Re. Angus Place Mine Extension Project (SSD 5602) Amended Development Application

Greater Blue Mountains World Heritage Area Advisory Committee

27 April 2020

LITHGOW SEAM DEPTH OF COVER CONTOURS

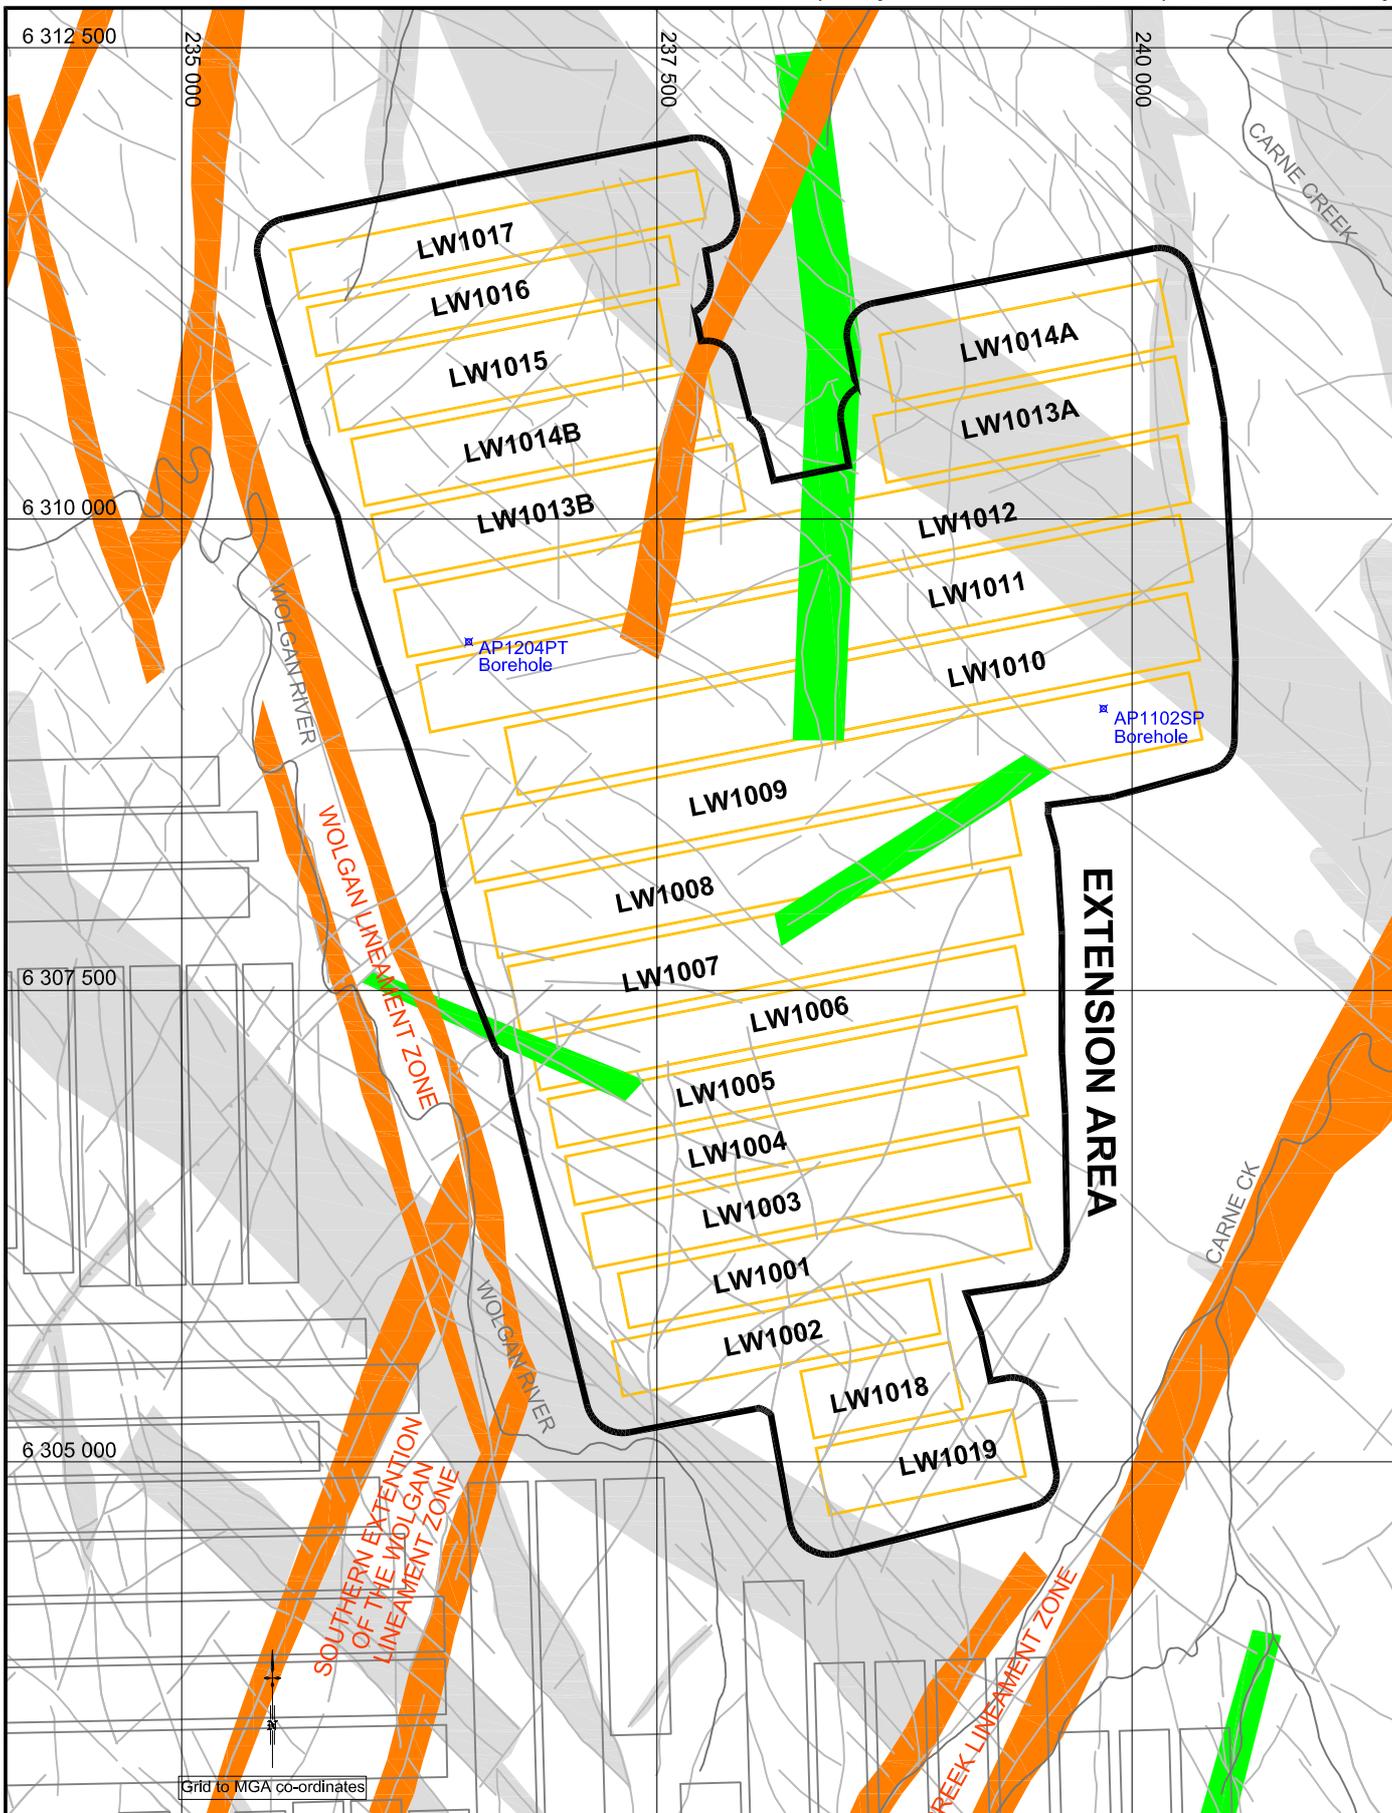
It is of serious concern that such far field impacts could extend to swamps outside the proposed Angus Place mine area. Groundwater drawdown modelling for this Angus Place Extension Project did not appropriately consider the possibility of lineaments draining surface waters, the cumulative impact from drawdown associated with the Springvale mine, or appropriately consider surface to seam fracturing. Such fracturing is predicted to occur up to 340 m for extractions of 3.4 m; depth of cover ranges between 270 m to 450 m, so fractures are likely to reach the surface anywhere depth of cover is <340 m.

## GEOLOGICAL STRUCTURES

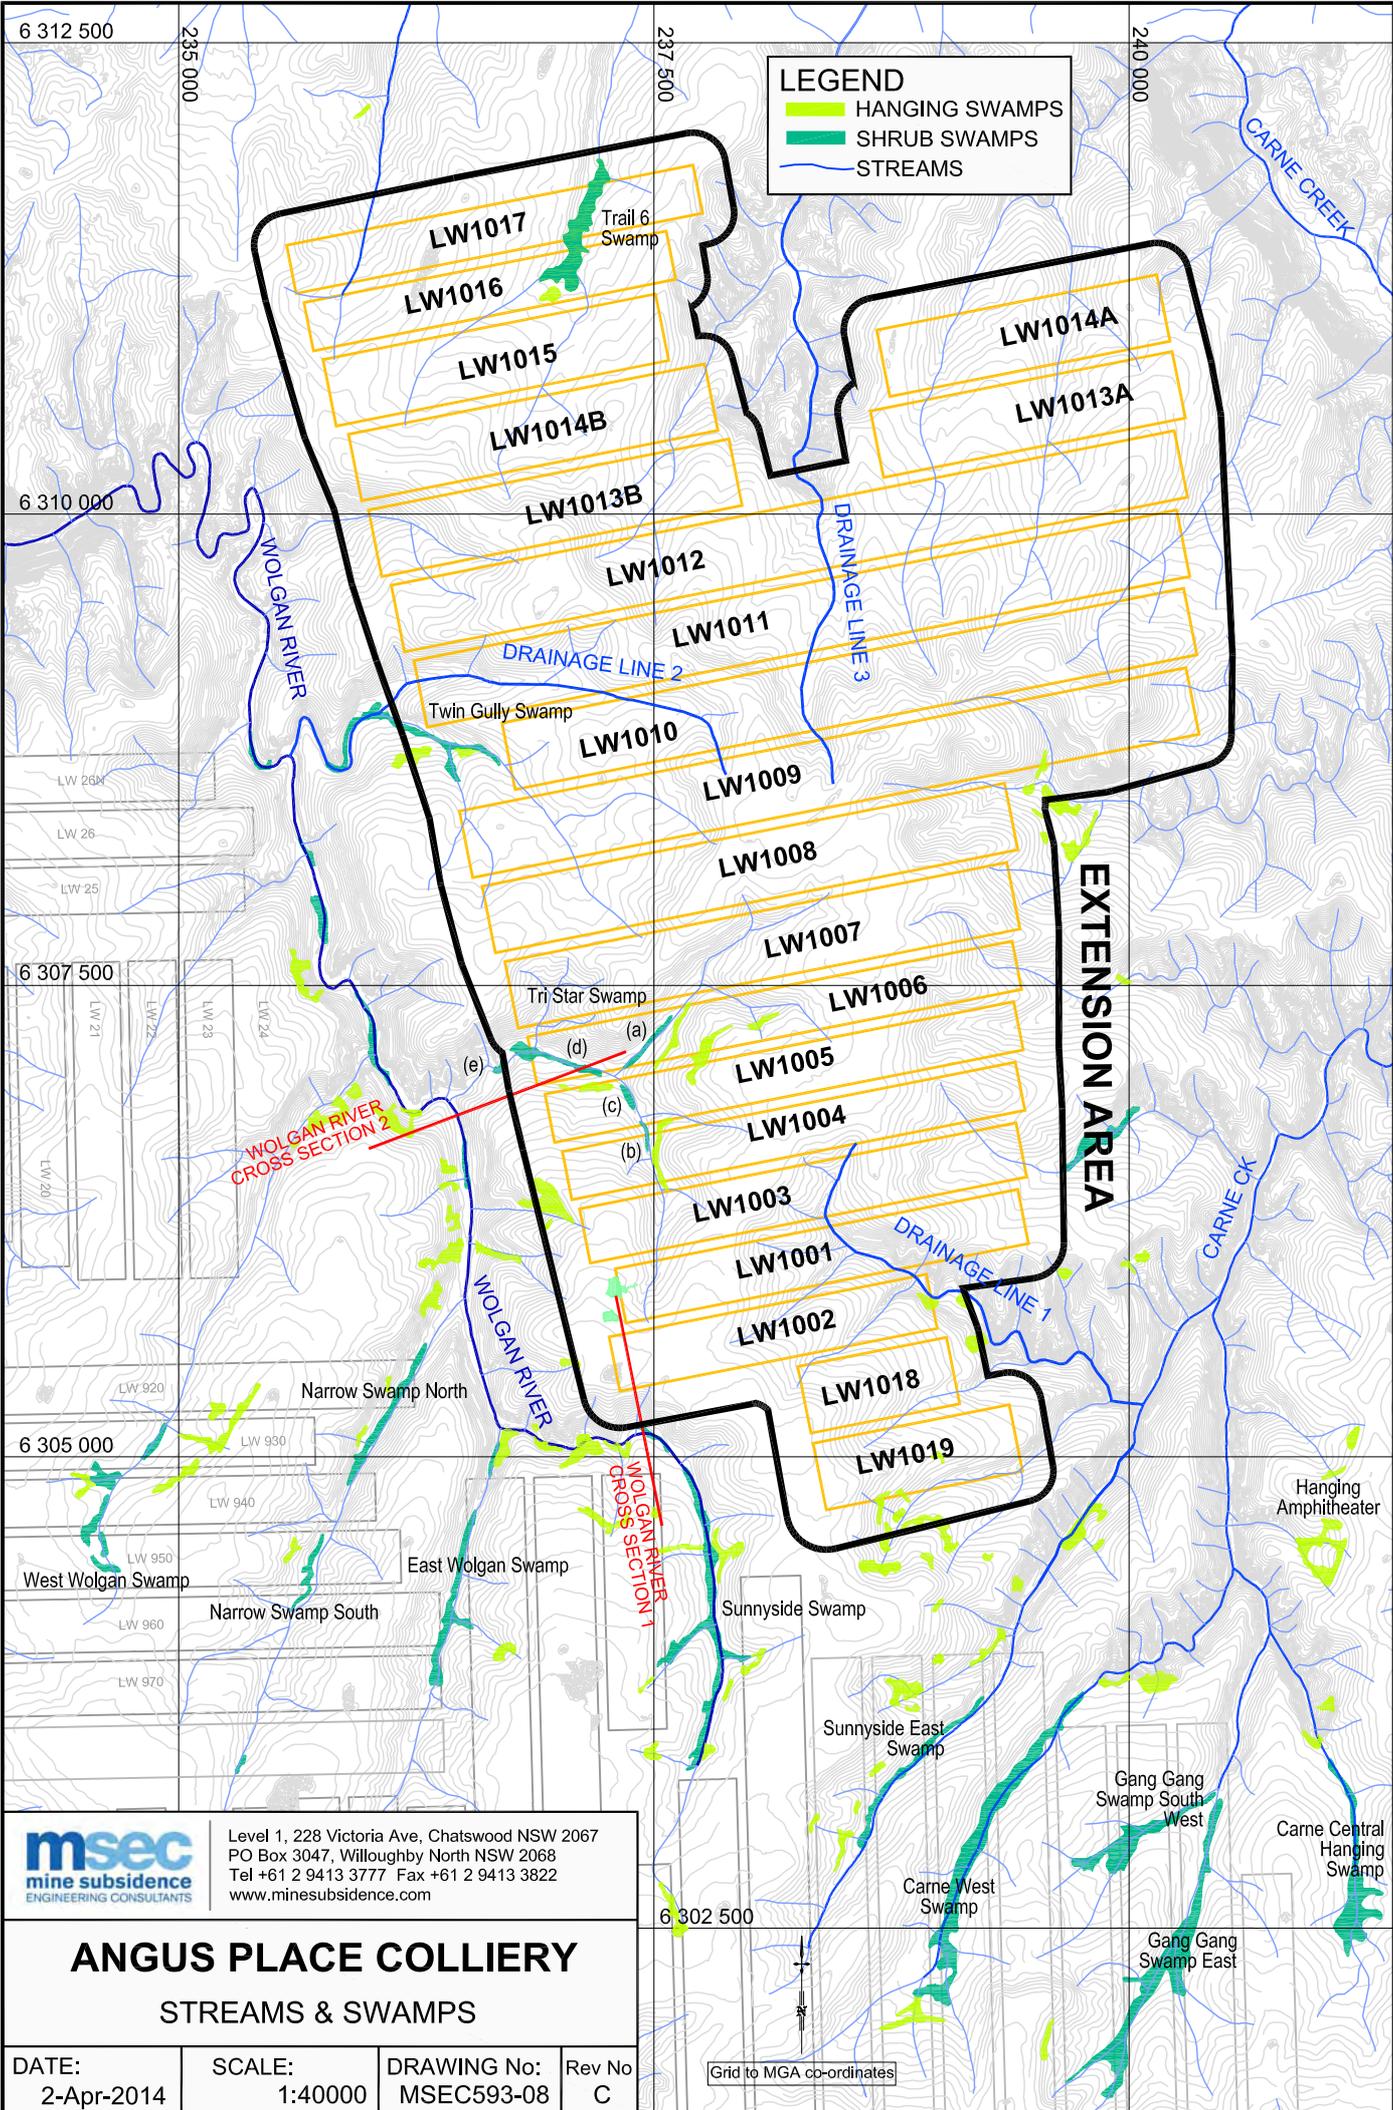
- Significantly reducing longwall widths to avoid surface to seam fracturing;
- Avoiding direct undermining of Twin Gully Swamp;
- Avoiding undermining the Type 2 lineament under Tri Star Swamp that is connected to the Type 1 Wolgan River lineament zone;
- Shortening LW1014 so that it does not undermine the Burralow aquifer that feeds Trail 6 swamp; and
- Reducing the proximity of longwalls to Crocodile and the Birds Rock swamps so as to maintain the Burralow formation aquifers that supply these two swamps.

**ANGUS PLACE COLLIERY**  
**STREAMS & SWAMPS**

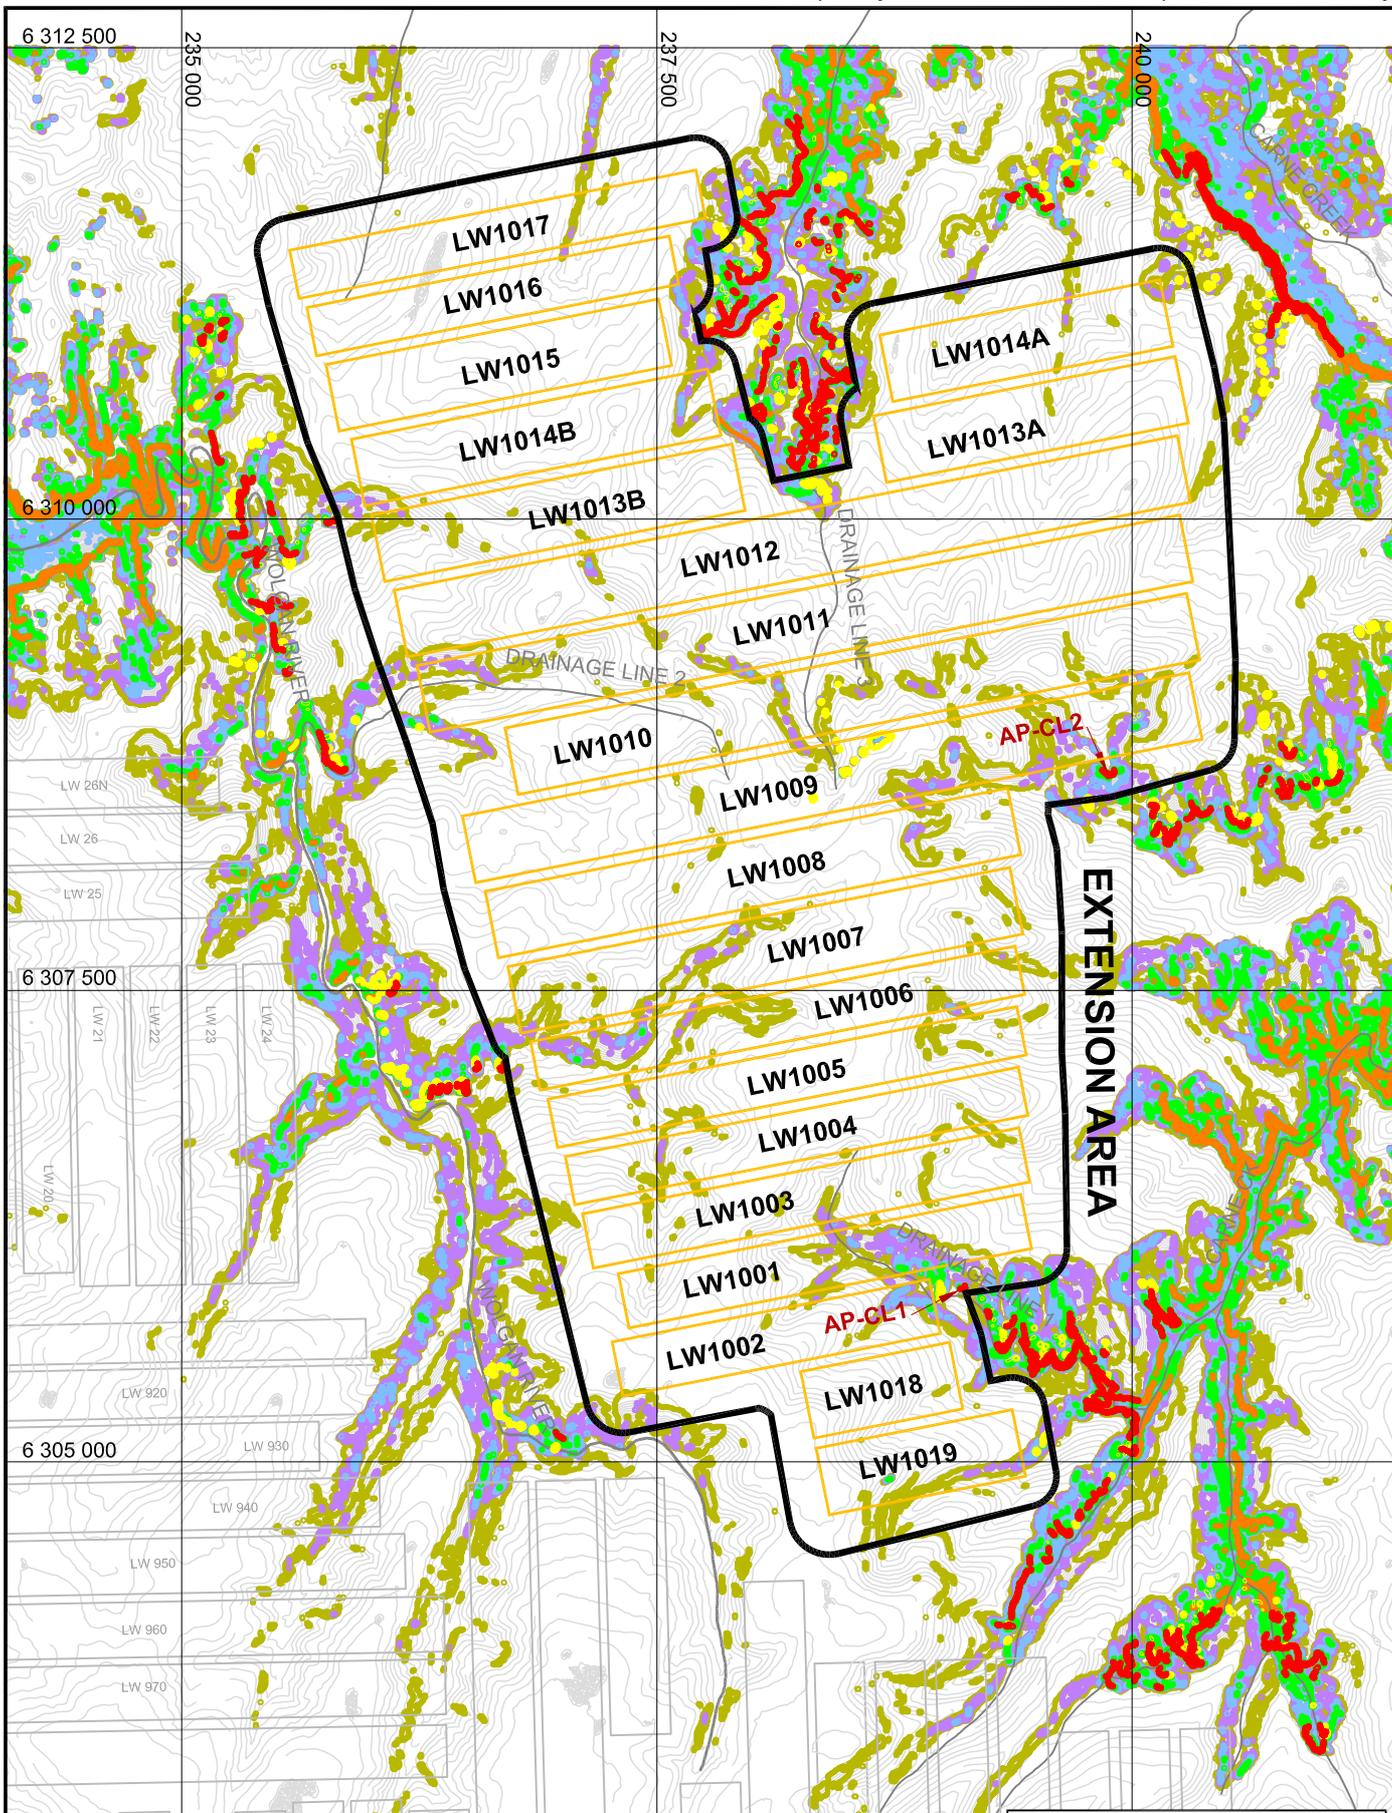
1. Potential loss of groundwater from endangered, groundwater-dependent, Newnes Plateau Shrub Swamp (NPSS) and Newnes Plateau Hanging Swamp (NPHS) ecological communities in the Gardens of Stone National Park and Wollemi National Park, in the World Heritage Area.

Groundwater drawdown is also possible, albeit to a somewhat lesser degree, outside the mine project area in the adjoining World Heritage Area as a result of 'far field impacts' associated with geological lineaments. The effect of even a much smaller 1-2 m drawdown, however, will be devastating for any of these swamps reliant upon a high or emergent water table. This could potentially include swamps in the headwaters of tributaries of Deanes Creek, Rocky Creek and Nayook Creek to the east.

In addition to the existing swamps which have been destroyed as a result of loss of groundwater, all swamps in the proposed mine area can be expected to be permanently and irreparably damaged as result of longwall mining-related subsidence and subsequent groundwater drawdown.
